Hume Coal Project & Berrima Rail Project - Environmental Impact Statement Review

Unit: Strategic Resource Assessment & Advice
Branch/Division: Geological Survey of NSW - Division of Resources & Geoscience
Subject: Hume Coal Project
Resource & Economic Assessment

Land and soil capability of project area (EMM mapping)

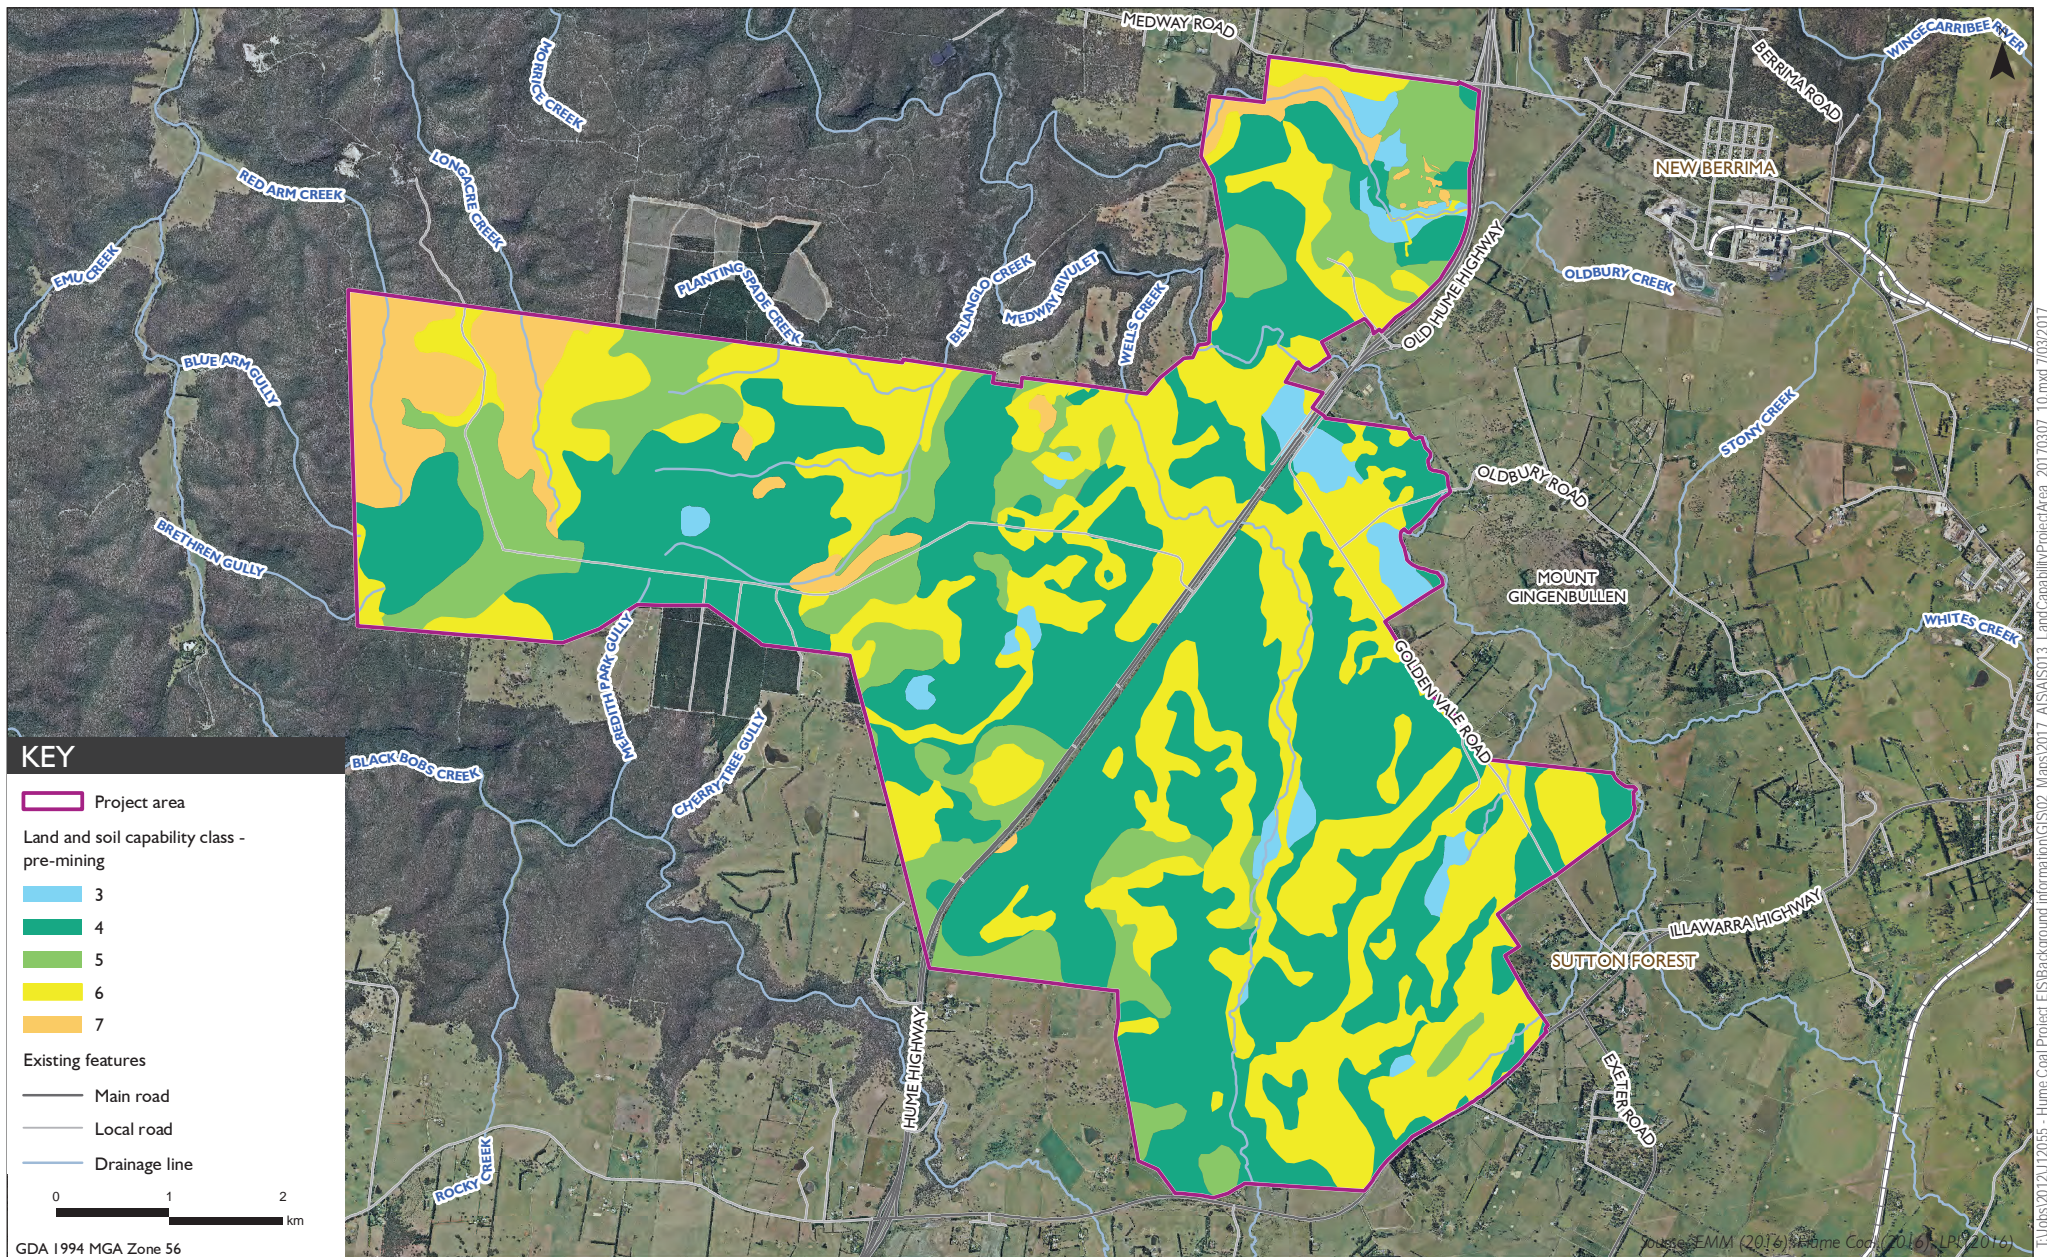
- The Proponent should provide further justification for the proposed reduction in Land and Soil Capability (LSC) for approximately 58 hectares of land subject to disturbance associated with establishment of surface facilities. Specifically, the identified 3 hectares of Class 3, 37 hectares of Class 4 and 18 hectares of Class 5 pre-mining land will be returned to lower quality Class 6 land at the end of the Project.

The Proponent should consider and assess options to increase the post mining LSC in the areas where this will decrease, as well as to assess any other options which will result in no net loss of agricultural land value as a result of the project. This may include consideration of offsets.
